WEST SUSSEX COUNTY COUNCIL CONSULTATION

TO:	Arun District Council FAO: Mr. D. Easton
FROM:	WSCC - Highway Authority
DATE:	28 March 2024
LOCATION:	Land East of Westergate Westergate
SUBJECT:	AL/11/24/OUT Hybrid application consisting of: 1) Outline permission for all matters reserved (except access) for up to 400 No dwellings and associated works and 2) Full planning permission for alterations to site access off Westergate Street and through Pine Close and east-west link road including a bridge over the Lidsey Rife. This application also lies within the parish of Barnham, falls within Strategic Site SD5, CIL Zone 1 (Zero Rated), affects the setting of listed buildings, affects the character and appearance of the Eastergate Church Lane Conservation Area, affects public rights of way. This application is the subject of an Environmental Statement.
DATE OF SITE VISIT:	1 st March 2024
RECOMMENDATION:	More Information Required
S106 CONTRIBUTION TOTAL:	£ See below for breakdown of highway-related contributions.

This is the second WSCC Highway Authority response to the above hybrid planning application consisting of: 1) Outline permission for all matters reserved (except access) for up to

Figure 4-1 - A29 Level Crossing AM Peak Queue Lengths

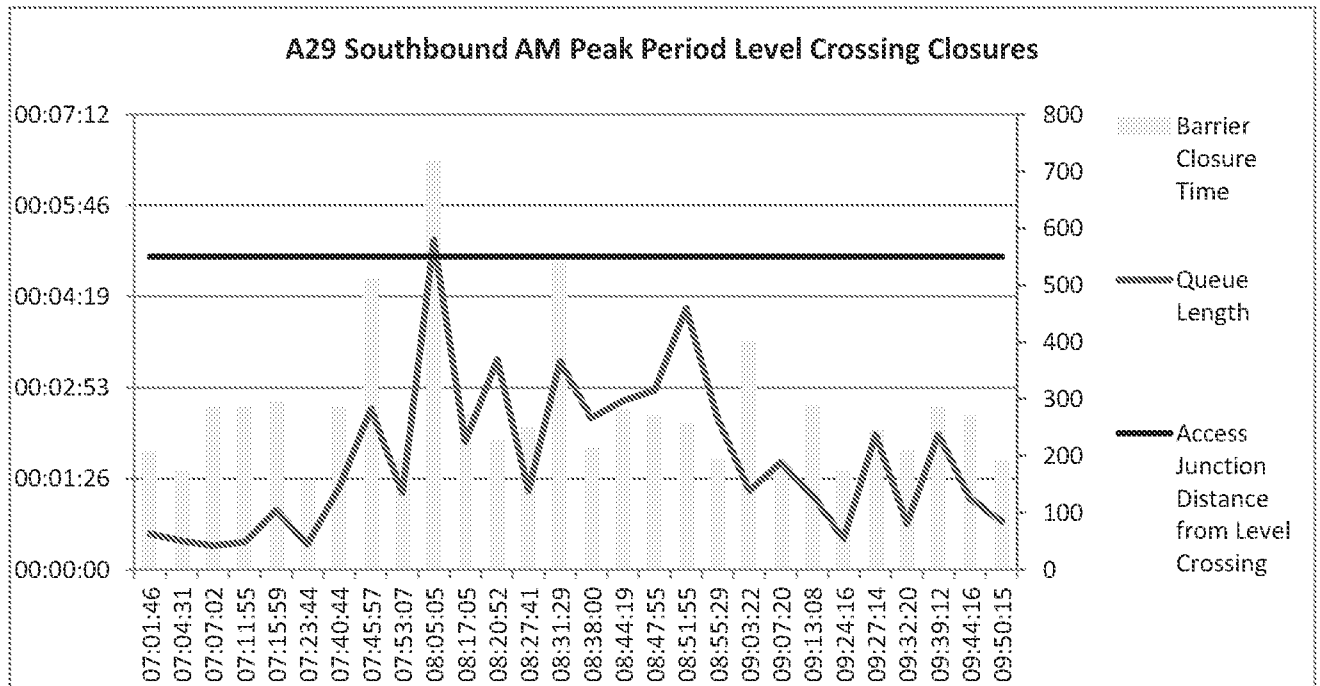
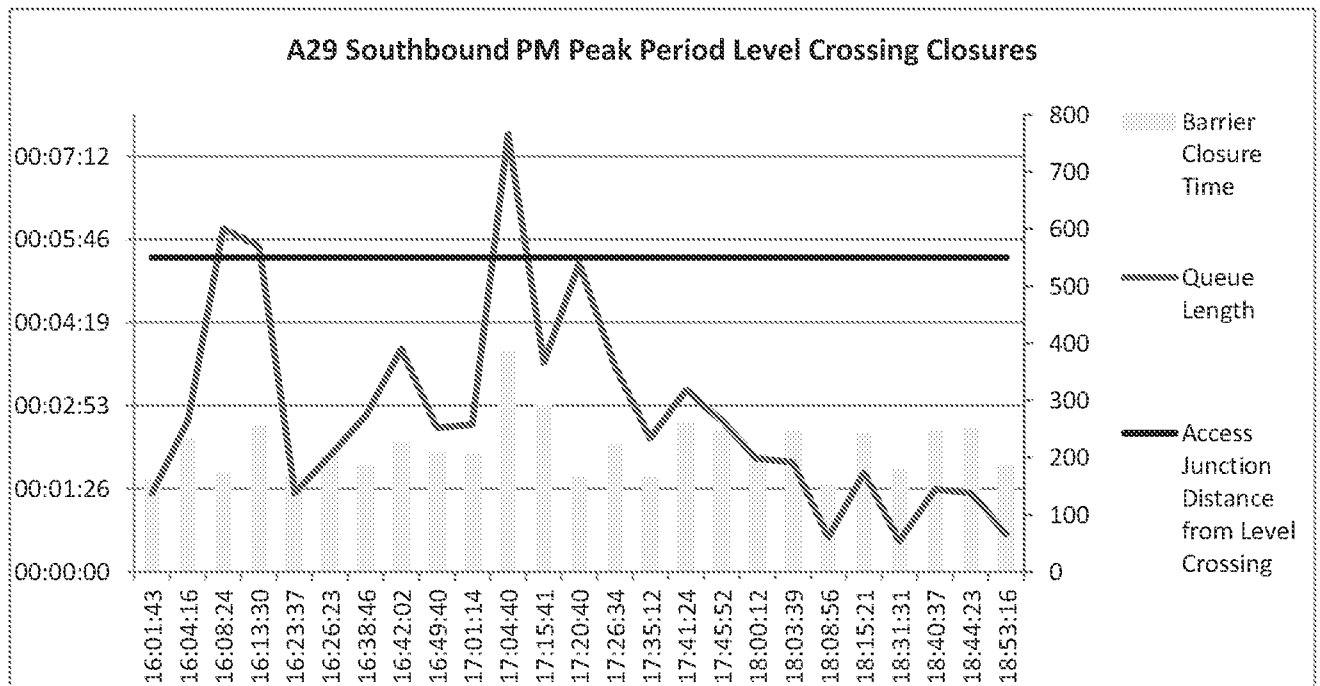
It is recommended that the applicant liaises with Network Rail to verify the above. If closure times are proposed to change, these should be considered in any transport modelling undertaken.

Figures 3-2 and 3-3 in the TA show that recorded queue lengths vary across each peak period but generally correlate with the length of the time the level crossing barrier is closed, with longer closures resulting in longer queue lengths. In the AM peak period, the queue length reaches the location of the proposed site access once (550m). This was a result of a six-and-a-half-minute barrier closure. This is one-and-a-half-minutes longer than any other closure time recorded and nearly four minutes longer than the average for the AM peak period. In the PM peak the recorded queue length extends beyond the proposed access junction location on two occasions as a result of multiple barrier closures over a short space of time (three times in seven minutes at worst).

JUNCTION AND RED LINE BOUNDARY
1:500

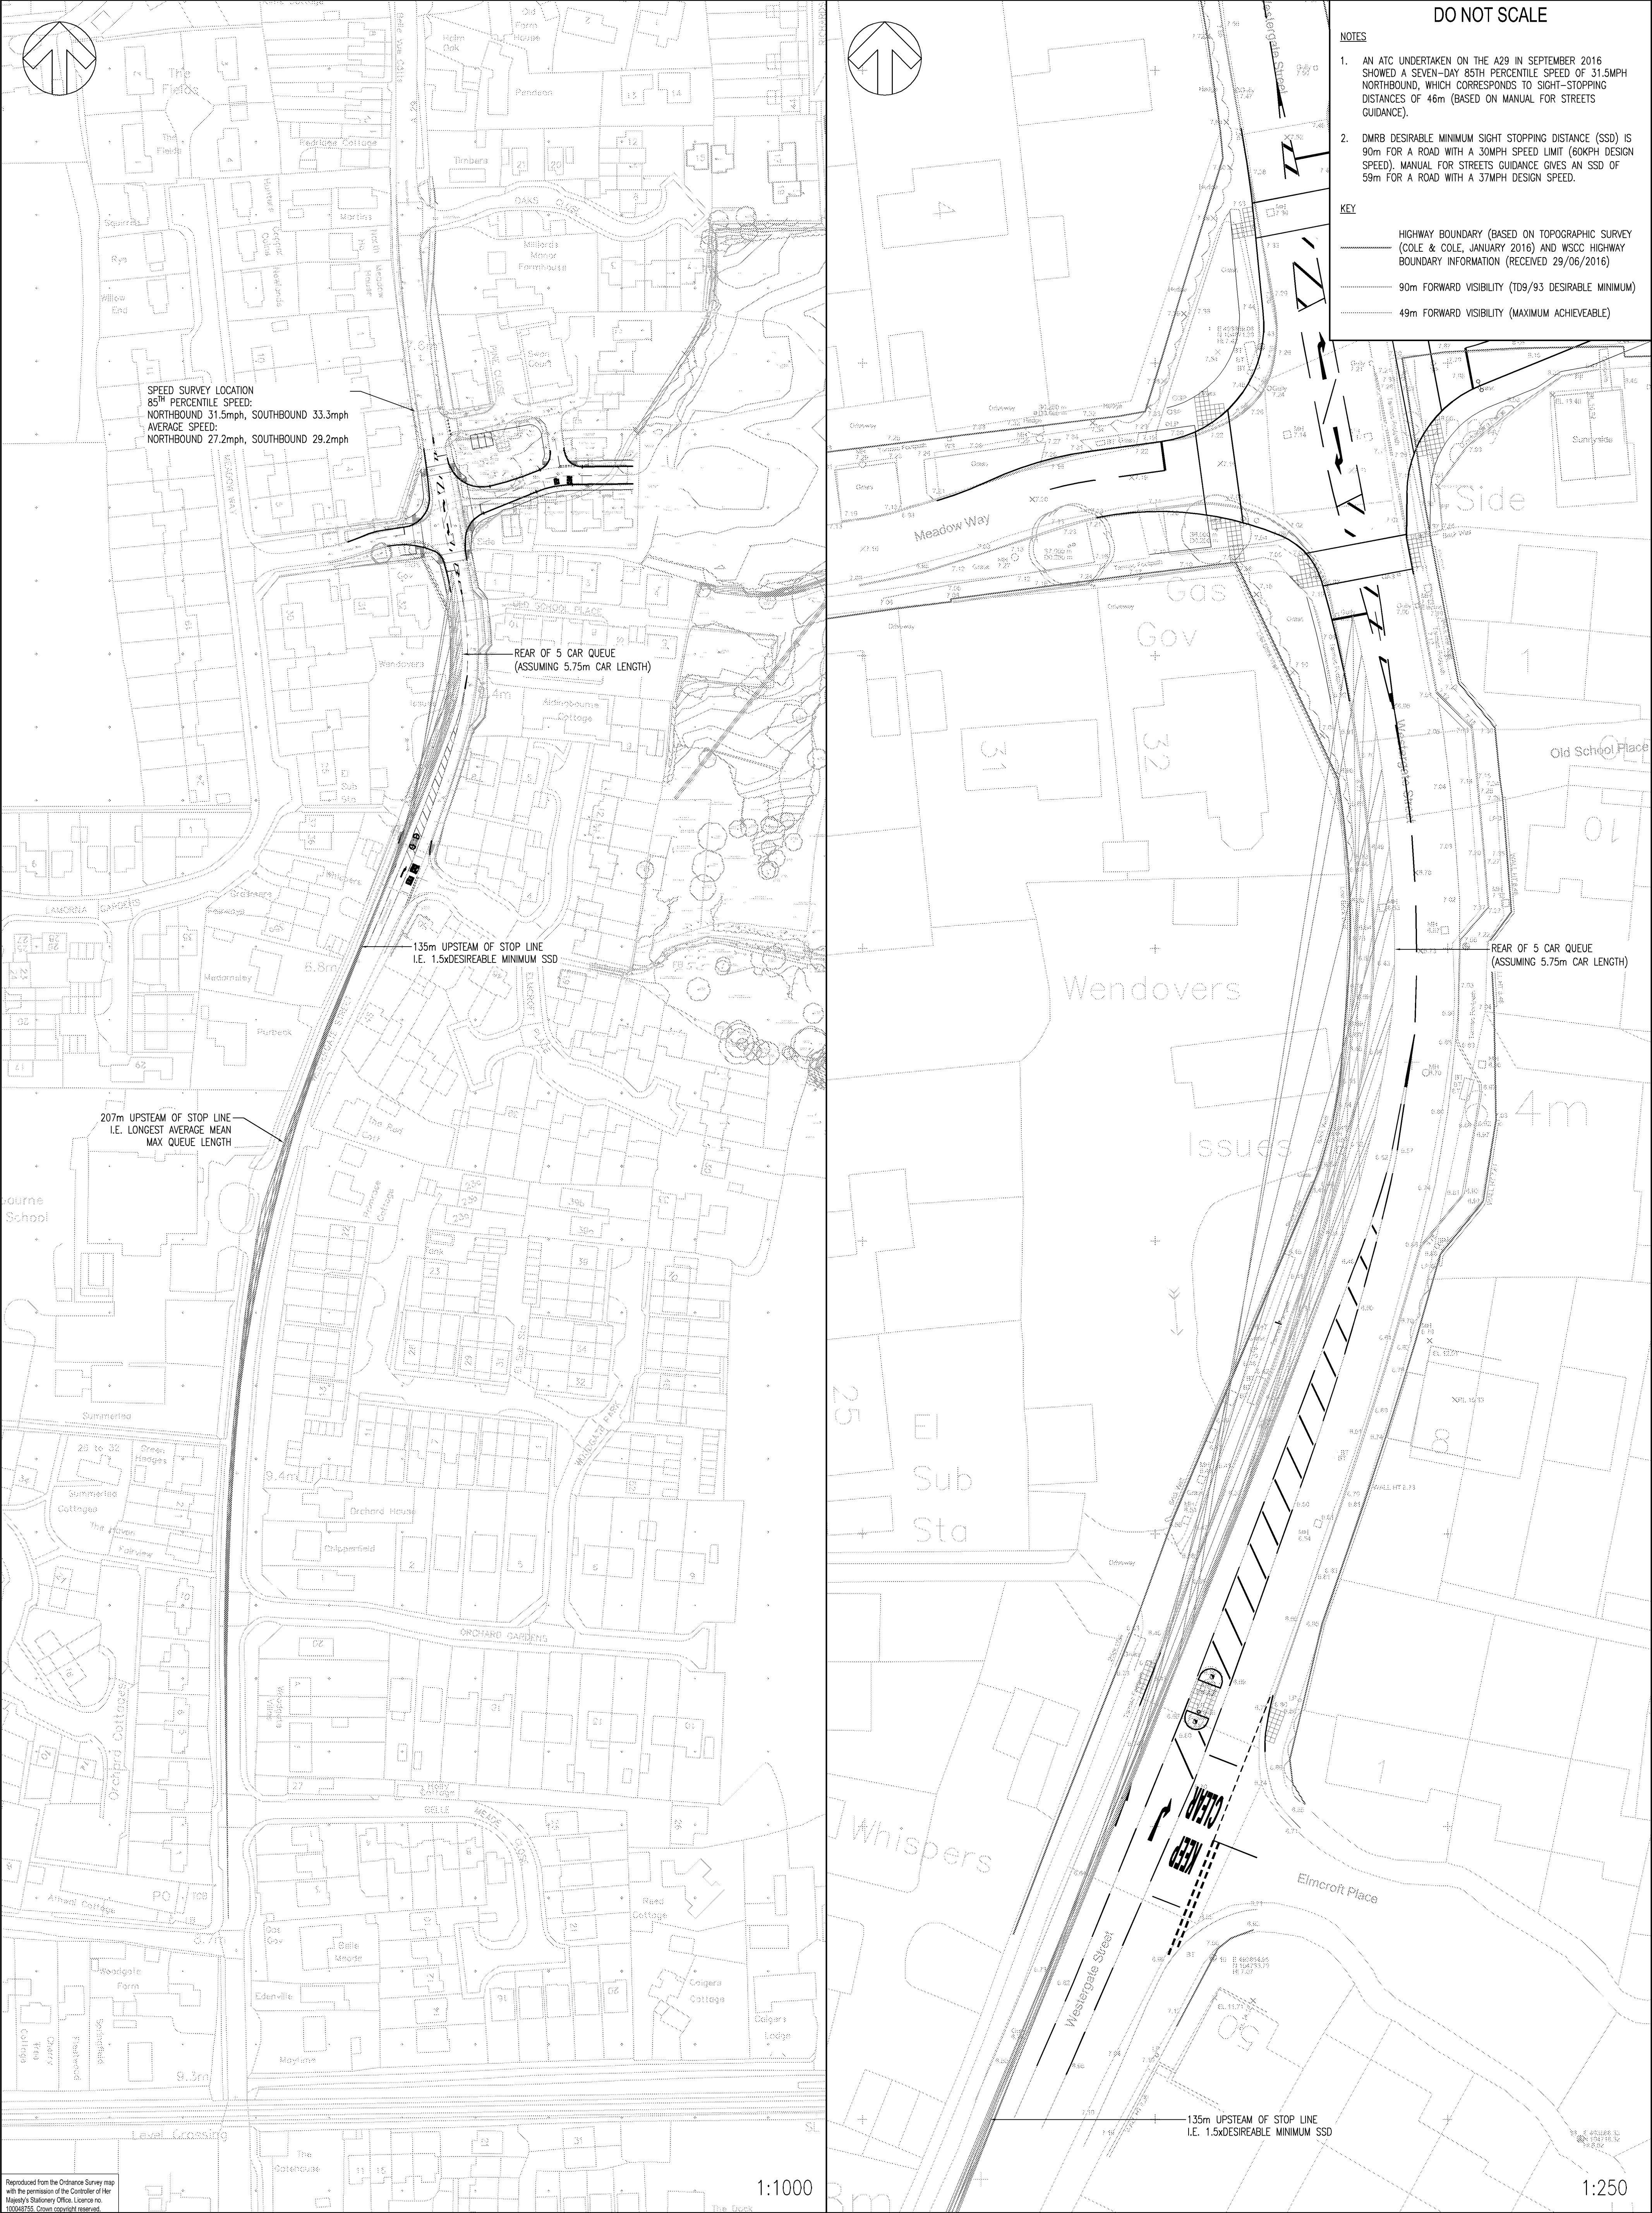
Appendix 'A' in the Scoping Report and email provided by the applicant's transport consultants WSP contains (at page 67 of the PDF) a drawing titled "Site Access Arrangement Option 3". It has been noted that annotations on this drawing either side of the access road state "*Wilson House Plot/Land to be regraded to suit detailed design of road*".

This drawing implies that third party land might be needed to facilitate the construction of the main site access road into the proposed development. If this is the case, then the landowner/s of the land in question would need to give permission to the applicant to use the land and, additionally, would need to be party to any highways works agreement to allow such works to take place.
